**KIRKLEES METROPOLITAN COUNCIL
INVESTMENT & REGENERATION SERVICE**

**DELEGATED DECISION TO DETERMINE PLANNING APPLICATIONS TO
CARRY OUT DEVELOPMENT WITHOUT COMPLIANCE WITH PLANNING
CONDITIONS PREVIOUSLY ATTACHED**

Reference No:	2023/70/92978/W
Site Address:	1, Woodsome Drive, Fenay Bridge, Huddersfield, HD8 0JR
Description:	Variation condition 2 (plans) on previous permission 2022/93872 for erection of two storey extensions to both side elevations, roof lift, single storey rear extension and alterations
Recommending Officer:	Lucy Taylor

Plans & Elevations - As Proposed

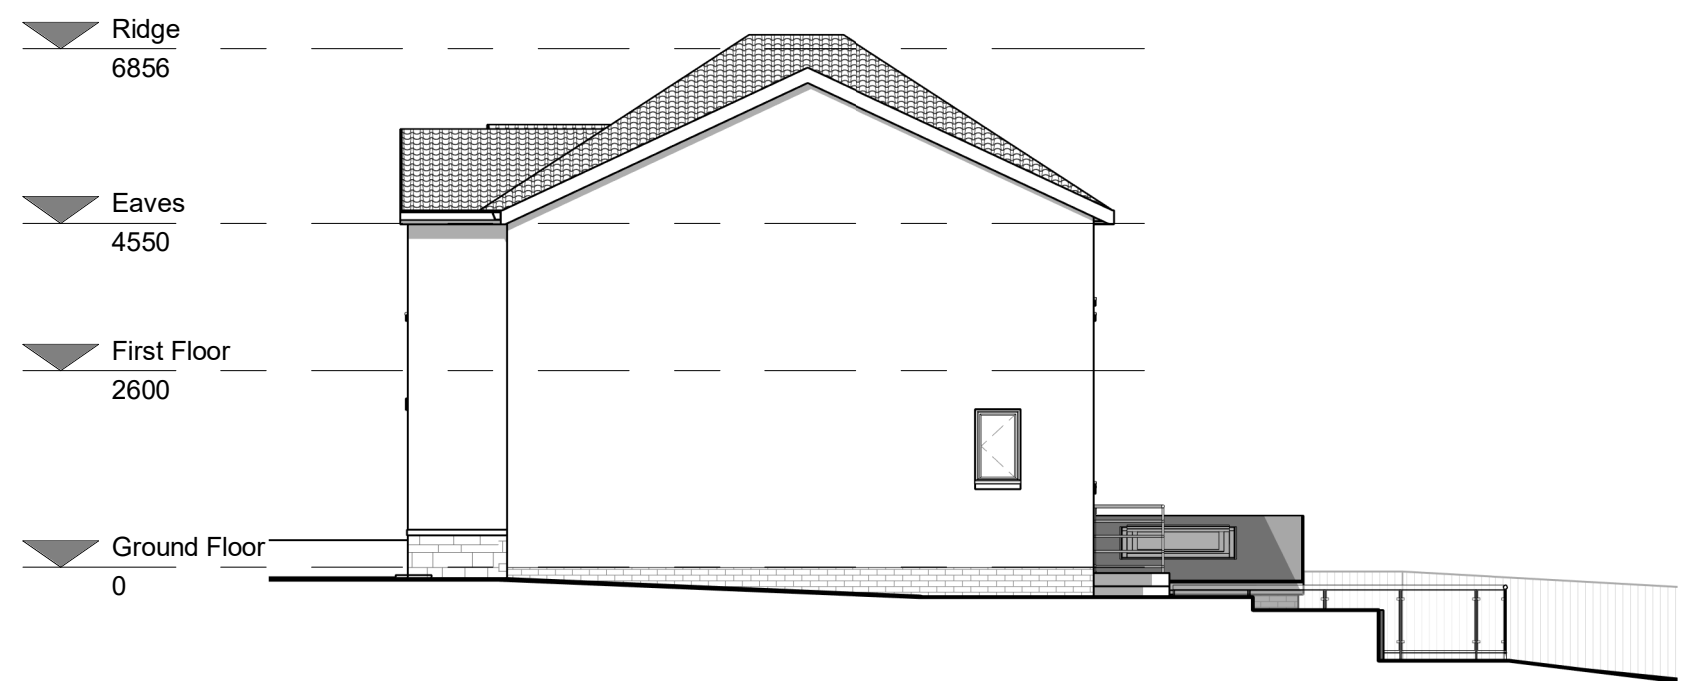
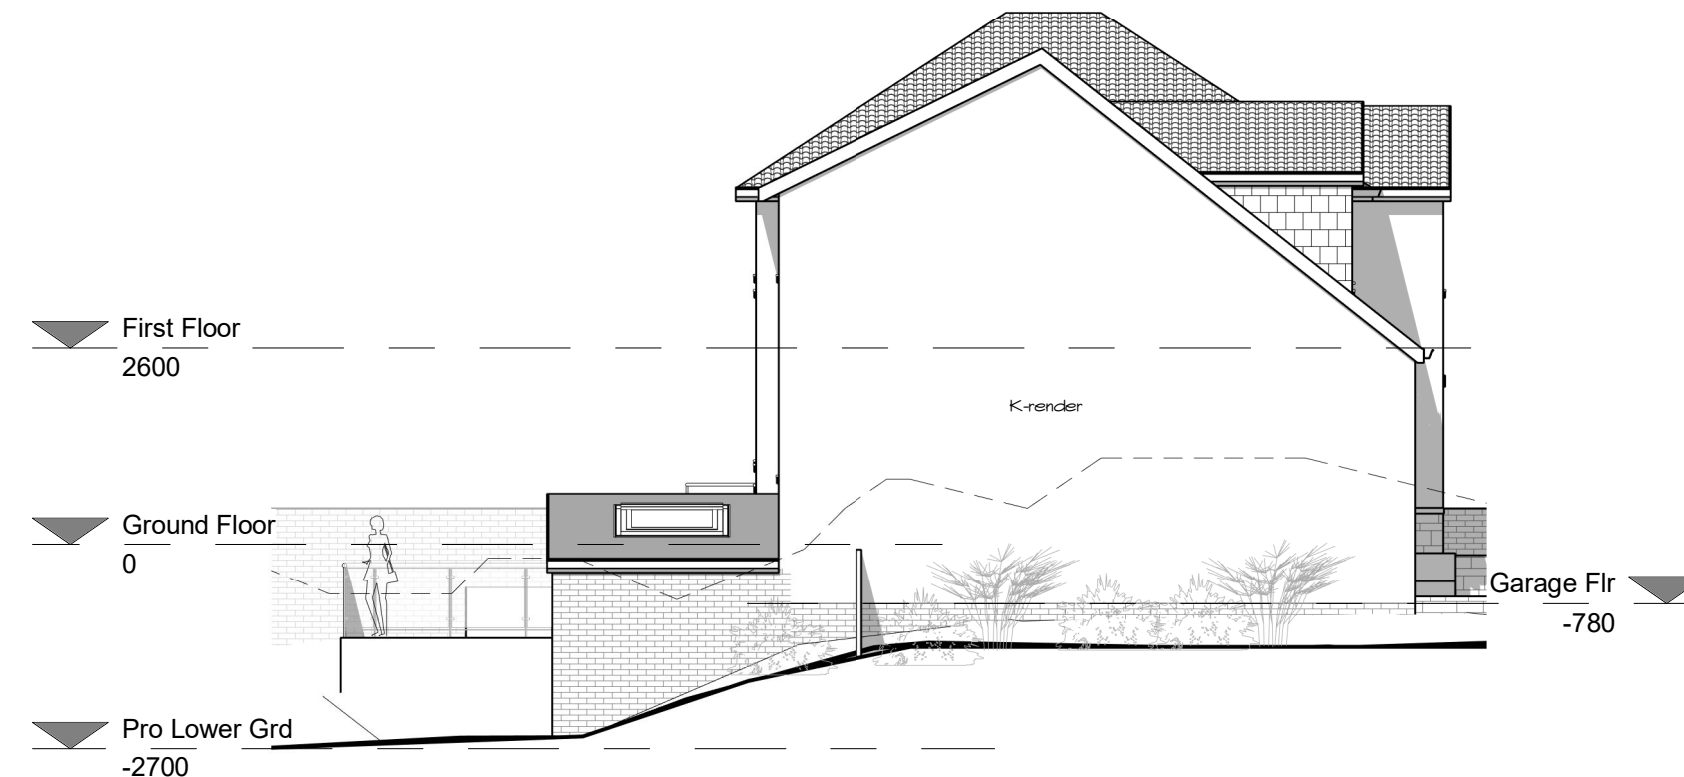
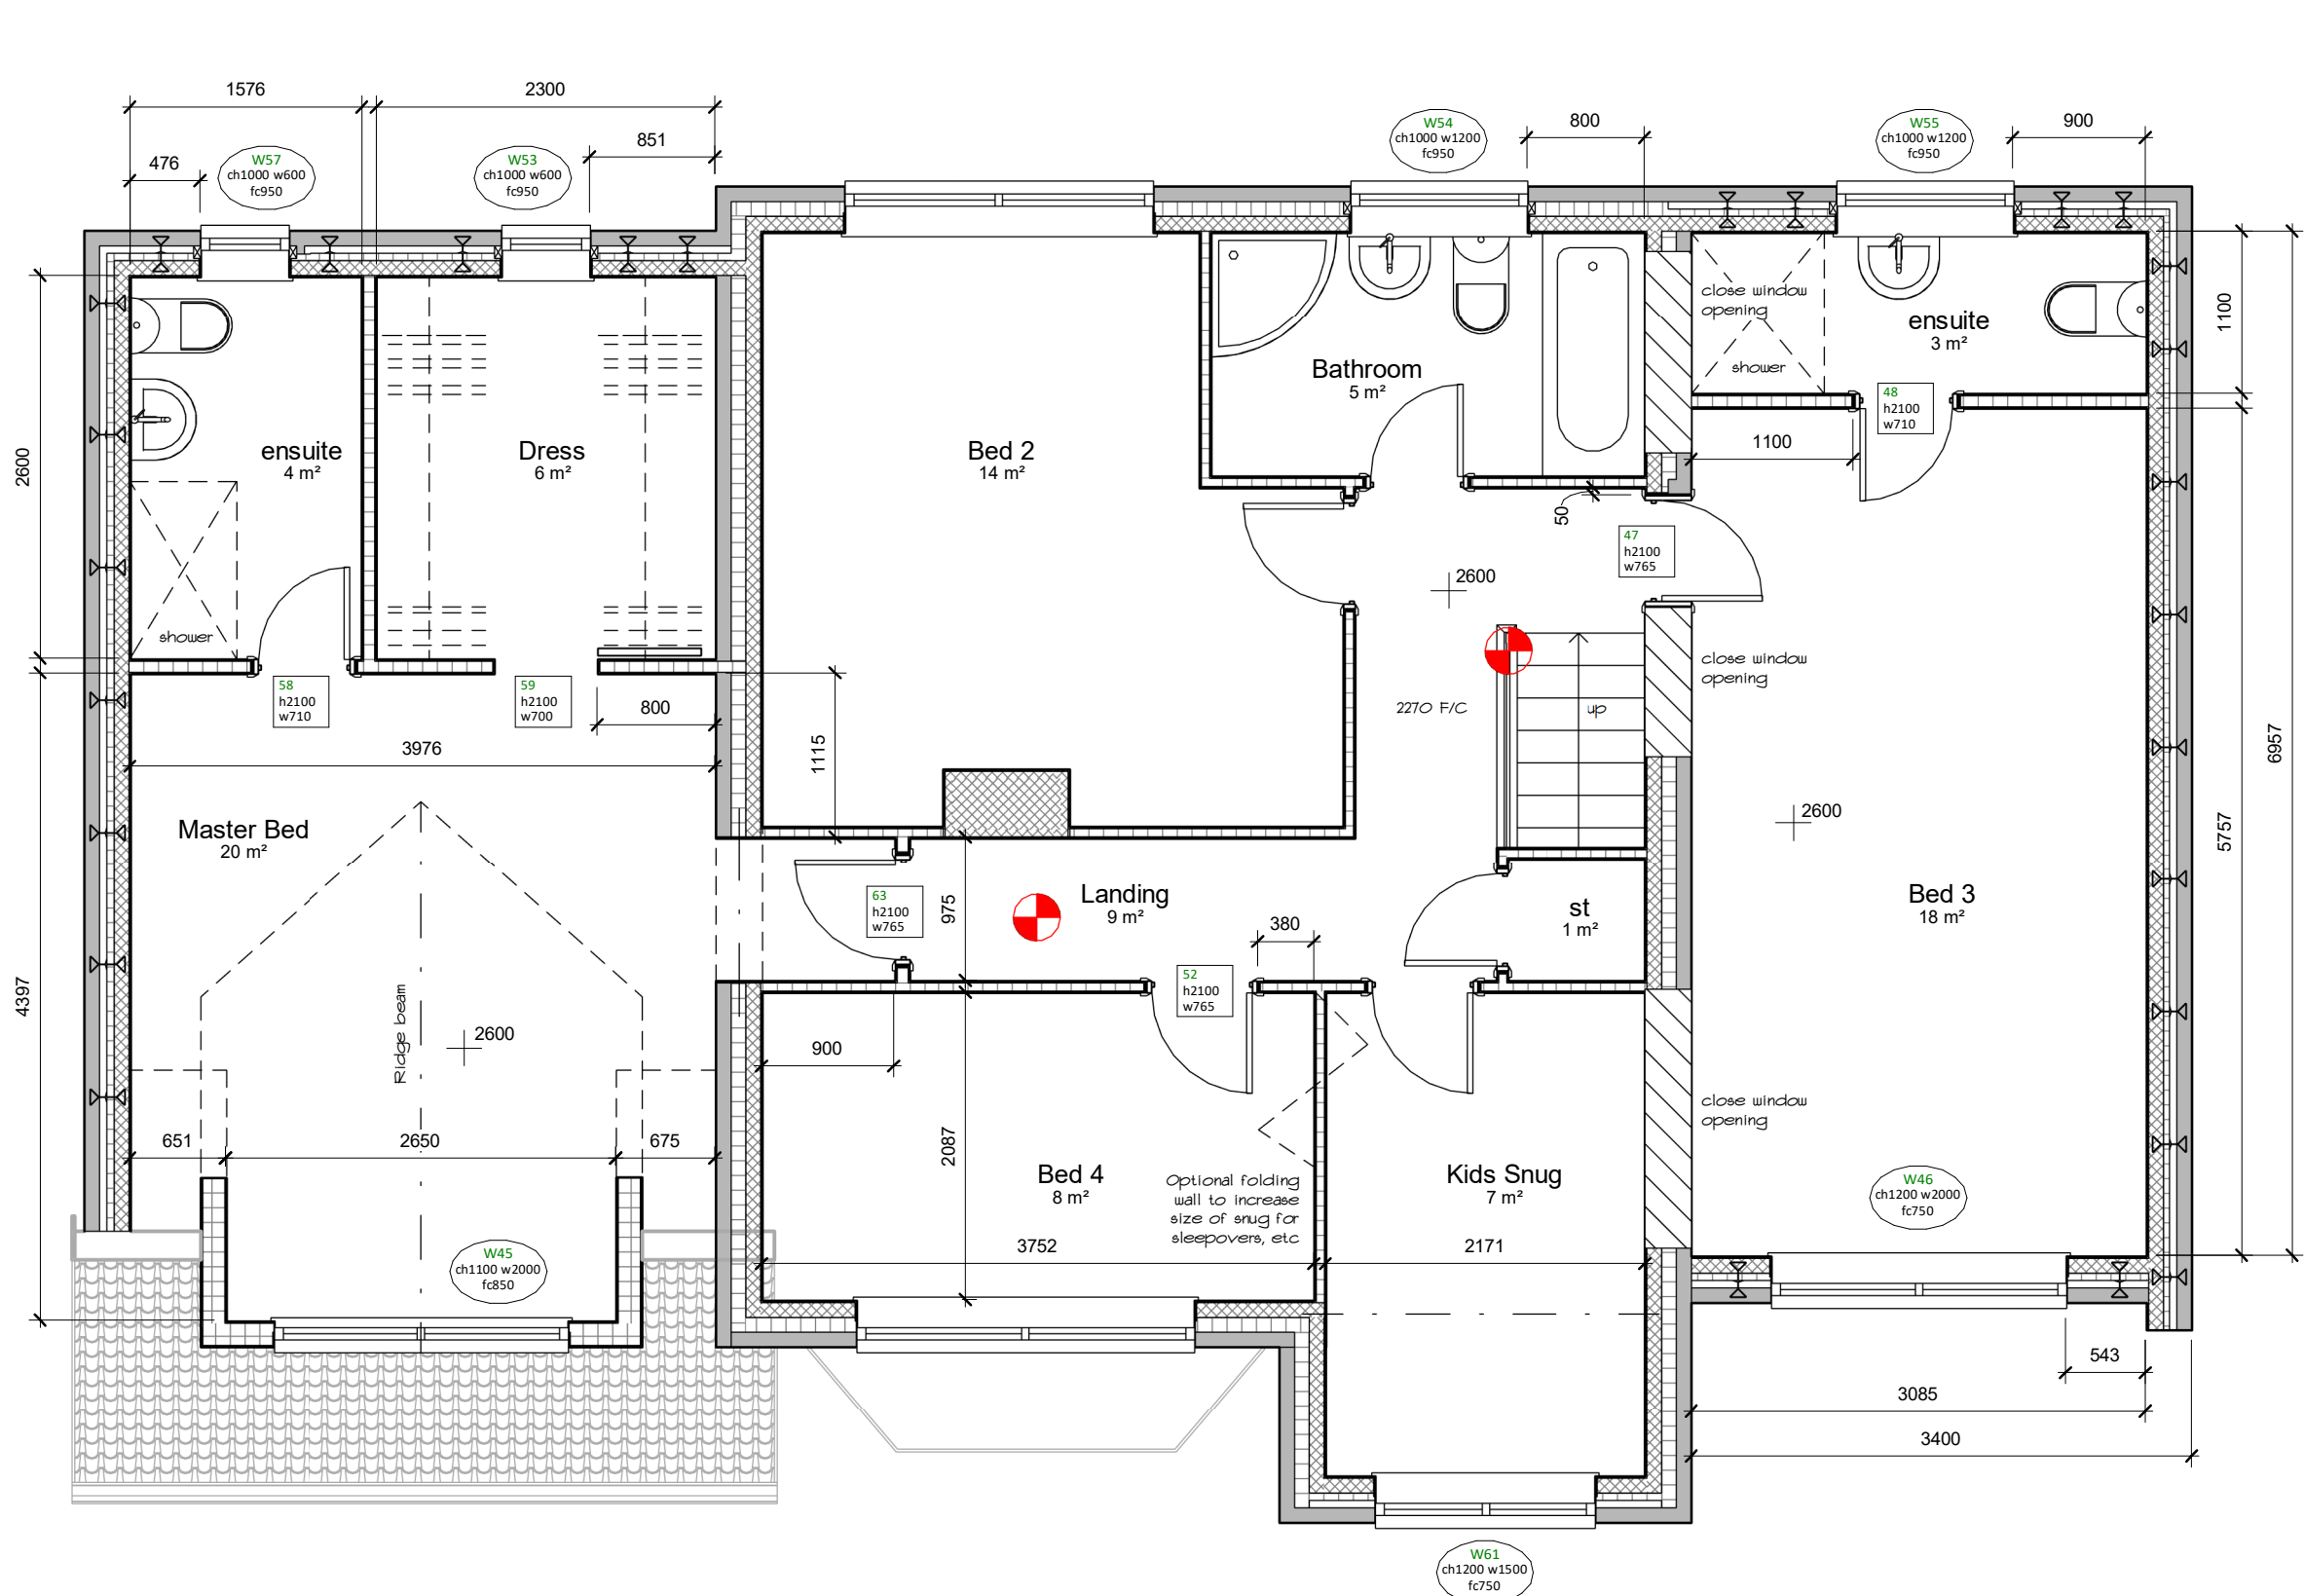
The application is seeking permission to vary condition 2 of the previous approval under 2022/93872. Amended plans were submitted (ref: A(10)-02) to show the following amendments to the two-storey front extension as granted permission under 2022/93872.

- Projection – 1.5 metres
- Width – 2.8 metres
- Maximum height – 6 metres

The application 2022/93872 the external walls of the two-storey front extension were to be faced in cement board cladding. This variation of conditions application proposes that the walls be faced in render.

In addition, the side elevations of the ground floor of the front extension are to be infilled, using render and course stone.

Fenestration detailing to the front porch would be altered, with the first floor window to reduce in size to match the existing windows to the host property and the glazing to the ground floor to be changed from a window to two glazed panels either side of the access door.

The scale of the proposed two-storey front extension would be increased marginally, with the proposed projection to be increased from 1.3 metres to

1.5 metres, bringing an overall increase in projection of 0.2 metres. The width and maximum height of the two-storey front extension would remain as granted under application 2022/93872. Given the minimal extent to which the projection is to be increased, it is not considered that this alteration would result in any detrimental impacts visually, with the front extension to remain significantly set back from the frontage of the site.

The proposal would see render used rather than cement board cladding. The ground floor of the extension would also be infilled to the side elevations using render and coursed stone. These modifications are concluded to be acceptable visually, with the proposed materials of construction in keeping with the rest of the property, whereby coursed stone and render are to face the front elevation of the dwellinghouse. It is considered that the proposed application of render would be more appropriate visually than the previously approved cement board cladding with regard to the context of the site and wider streetscene.

The modifications to fenestration are also considered to achieve a design which is more in keeping with the architectural form of the dwellinghouse, particularly with regard to the replacement of the large first floor window under application 2022/93872 for a regular window which matches those proposed elsewhere on the dwellinghouse.
